Your Reference SSD-68708456 & SSD-68939460
Our Reference NCA/13/2024
Contact Bianca Lewis
Telephone 9806 5531
Email blewis@cityofparramatta.nsw.gov.au

City of Parramatta Council submission to 242-244 Beecroft Road Epping – Amending Detailed Design and Amending Concept State Significant Development Applications

Attachment A: Detailed Submission

Figure 1 Proposed vehicle site access strategy

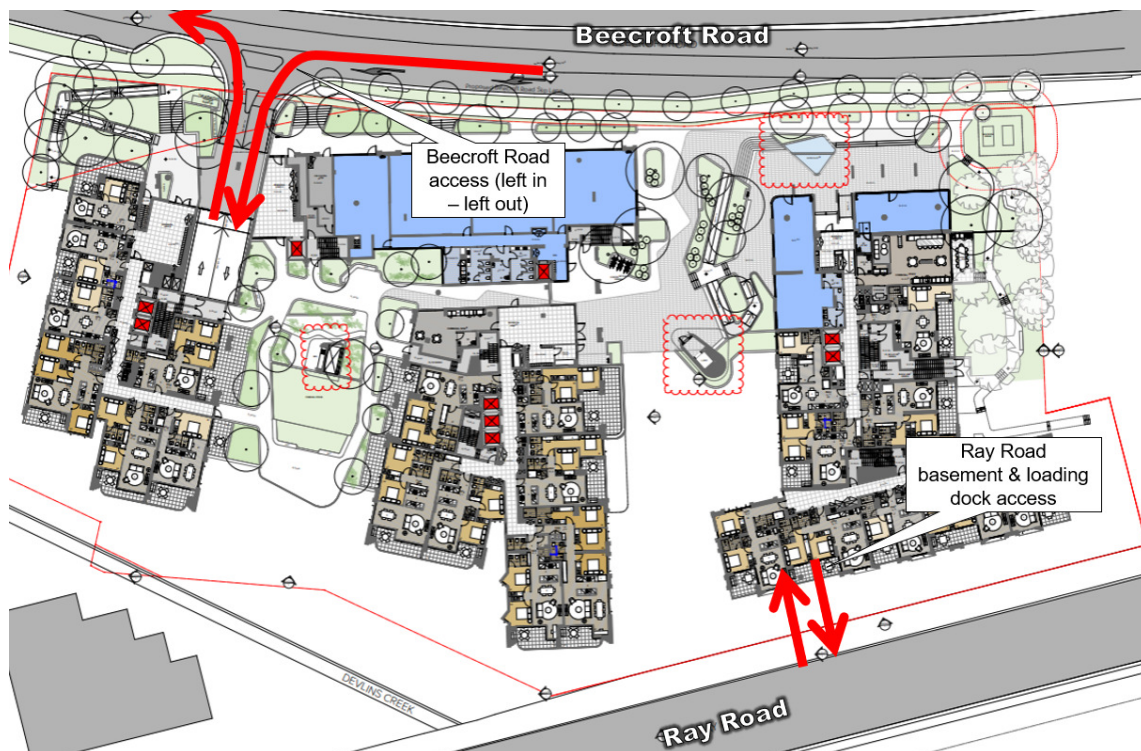
The submitted Operational Waste Management Plan (Elephants Foot, 5 June 2024) indicates that Council will be responsible for residential waste collection. A residential development of this size requires waste collection with a Heavy Rigid Vehicle (HRV). The Plan indicates that the development will be accessed with a HRV using a turntable. The Traffic Impact Assessment and Architectural Plans submitted only provide vehicle swept paths for Small and Medium Rigid Vehicles.

- the development has not demonstrated that it allows for a Heavy Rigid Vehicle to enter and exit the site in a forward direction and to adequately manoeuvre once onsite, without the use of a turntable.
- the development has not demonstrated that it allows the route of travel for the waste vehicle is to be of sufficient strength and quality to support a Heavy Rigid Vehicle;
- the development has not demonstrated that the grades of entry and exit ramps and manoeuvrability (including turning circles) are not to exceed the capabilities of the waste collection vehicle and are to comply with Australian Standard AS 2890.2 Parking Facilities: Off-Street Commercial Vehicle Facilities; and
- the development has not demonstrated that it allows minimum height of the entry and vehicle route of travel is to be 4.5 metres to allow clearance for waste collection vehicles.

Council Officers therefore recommends that the requirements of Appendix 2, PDCP 2023 requirements be addressed.

Figure 3 Swept path analysis – loading area

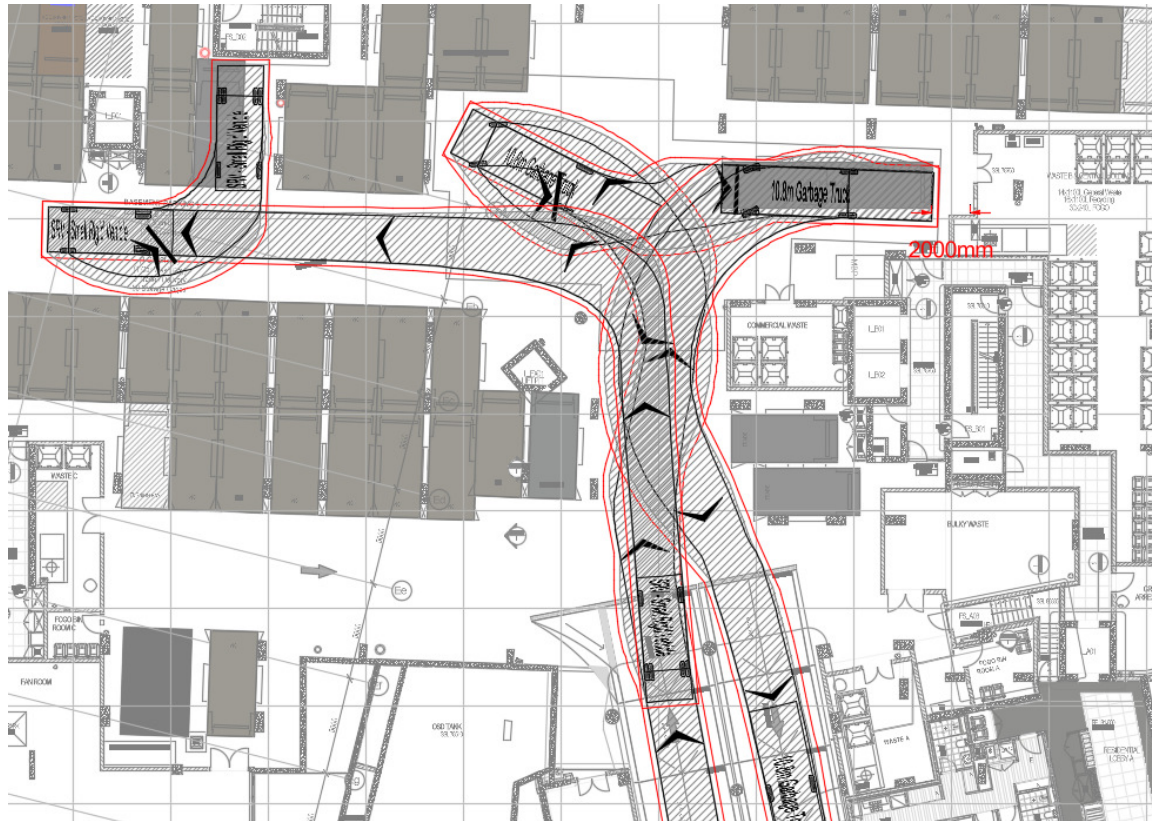
The number of Loading bays is unchanged with 1 MRV bay, 1 SRV bay and 2 B99 bays for deliveries and service vehicles. These are considered sufficient for the proposed development. However, the updated plans now show additional columns within the loading bays which is obstructing access to the MRV space. The applicant must revise the swept paths or alter the basement layout to ensure safe access to the site.
